September 20, 2022

RE: Comment Response Letter – Monument Hill
1st Rezone Review Comment Responses
File #: P2214 (EA2280)

COMMENT RESPONSE LETTER

MONUMENT HILL REZONE

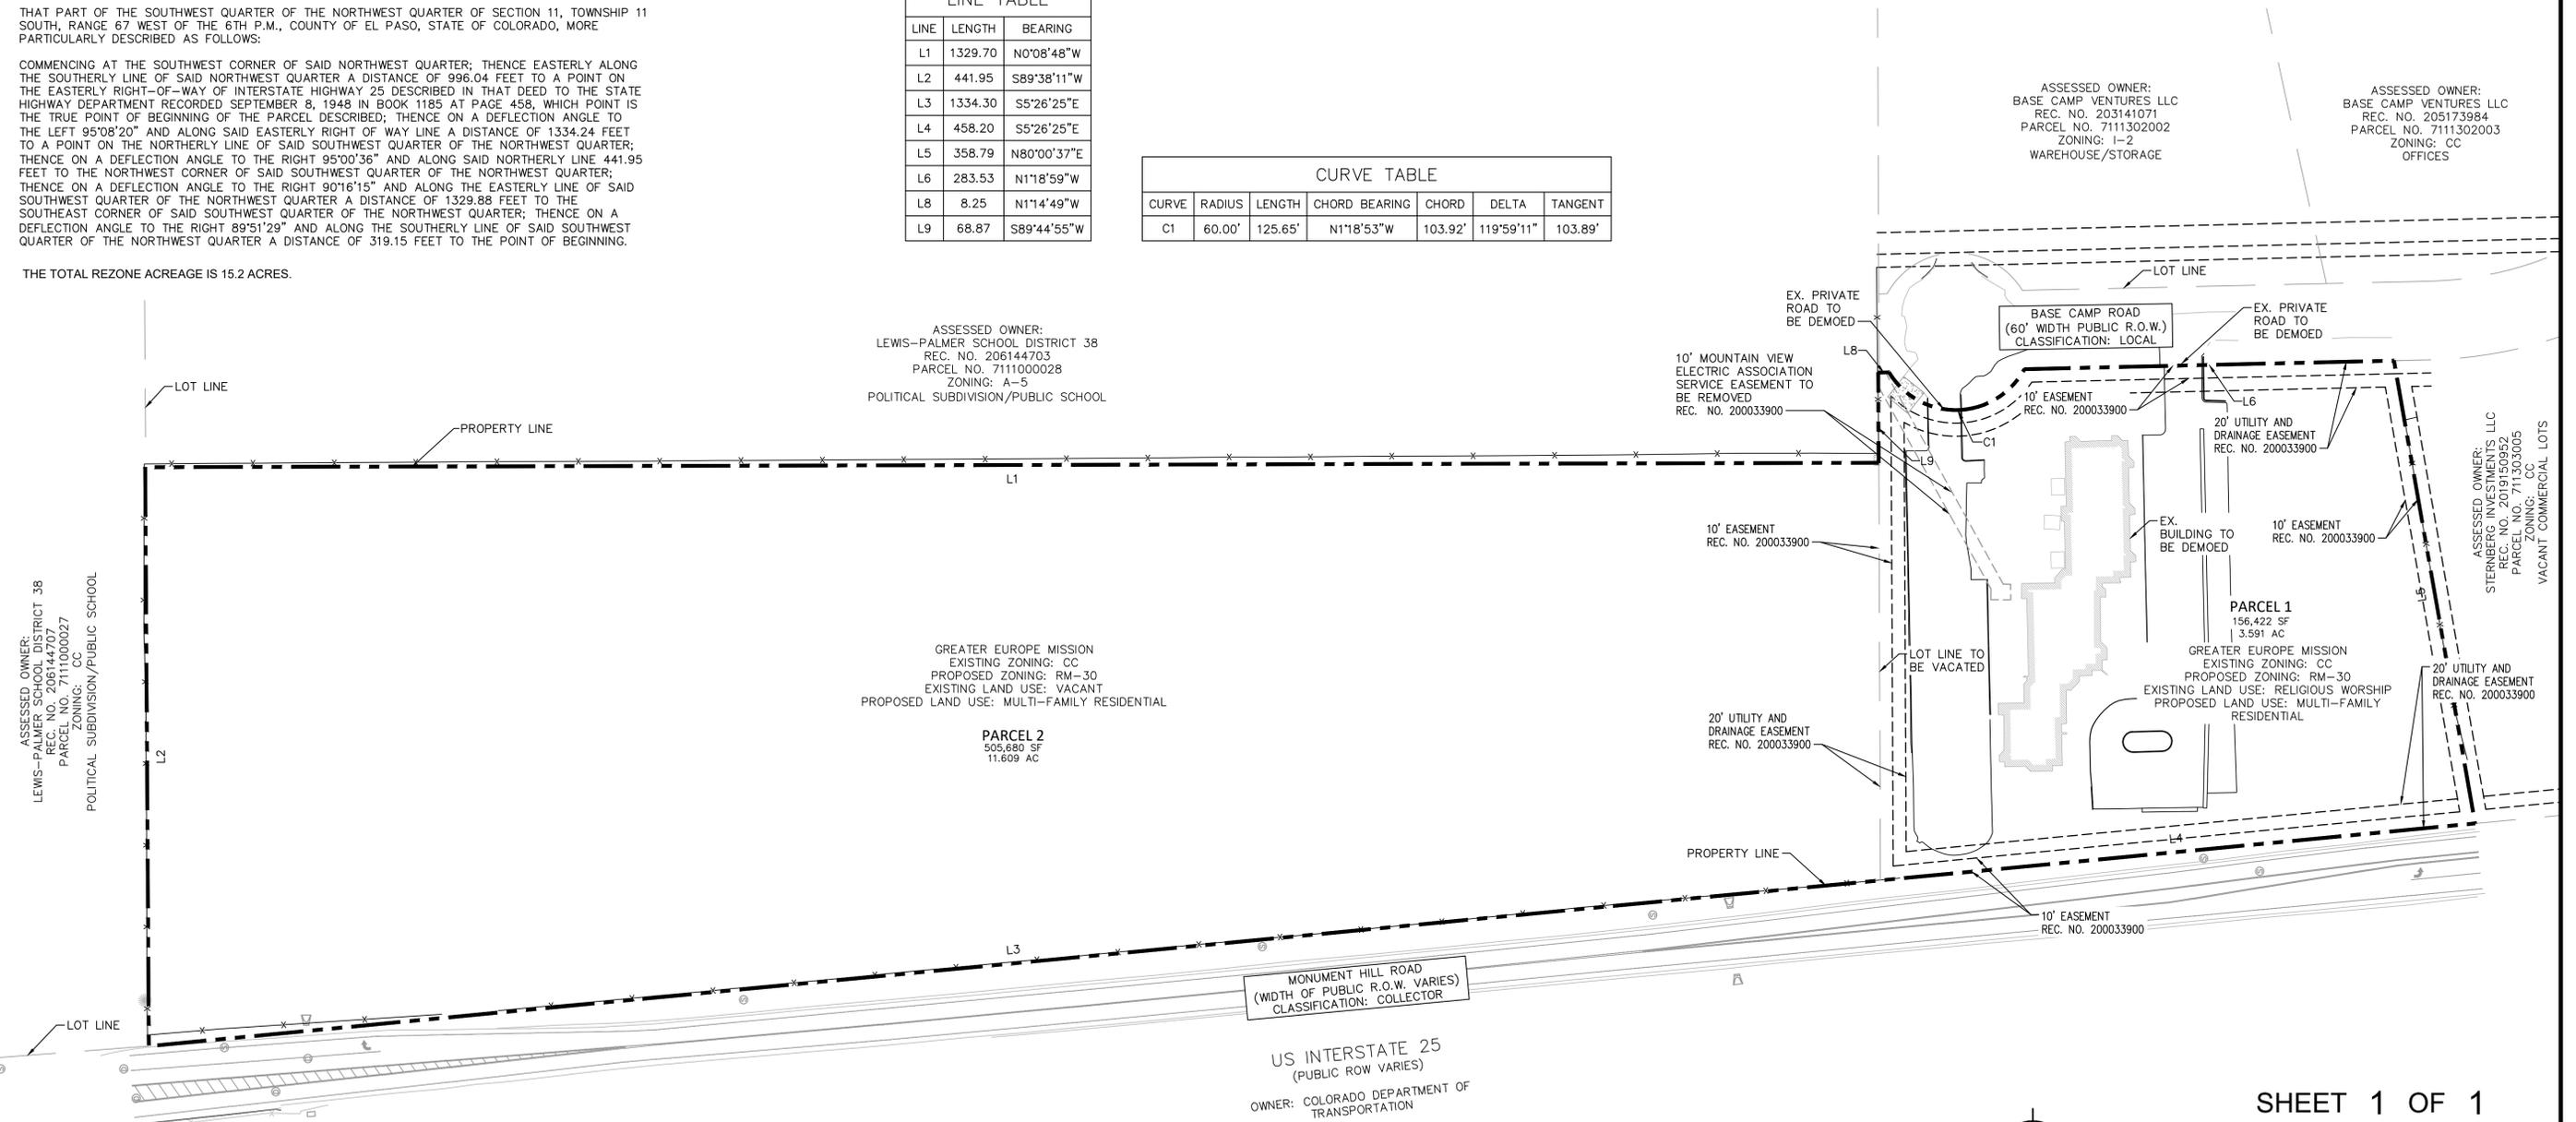
View	PCD Project Manager	Please update the TIS to include the data when school is in session. attached is a request for the title commitment page.	8/26/2022 1:38:46 PM	Please see the separate response letter for the TIS comments and redlines.
View	PCD Project Manager	zoning map	8/26/2022 1:39:10 PM	The PCD redlines on the zoning map have been addressed. The existing structures are shown, the existing roadways are shown, and the existing easements are shown.
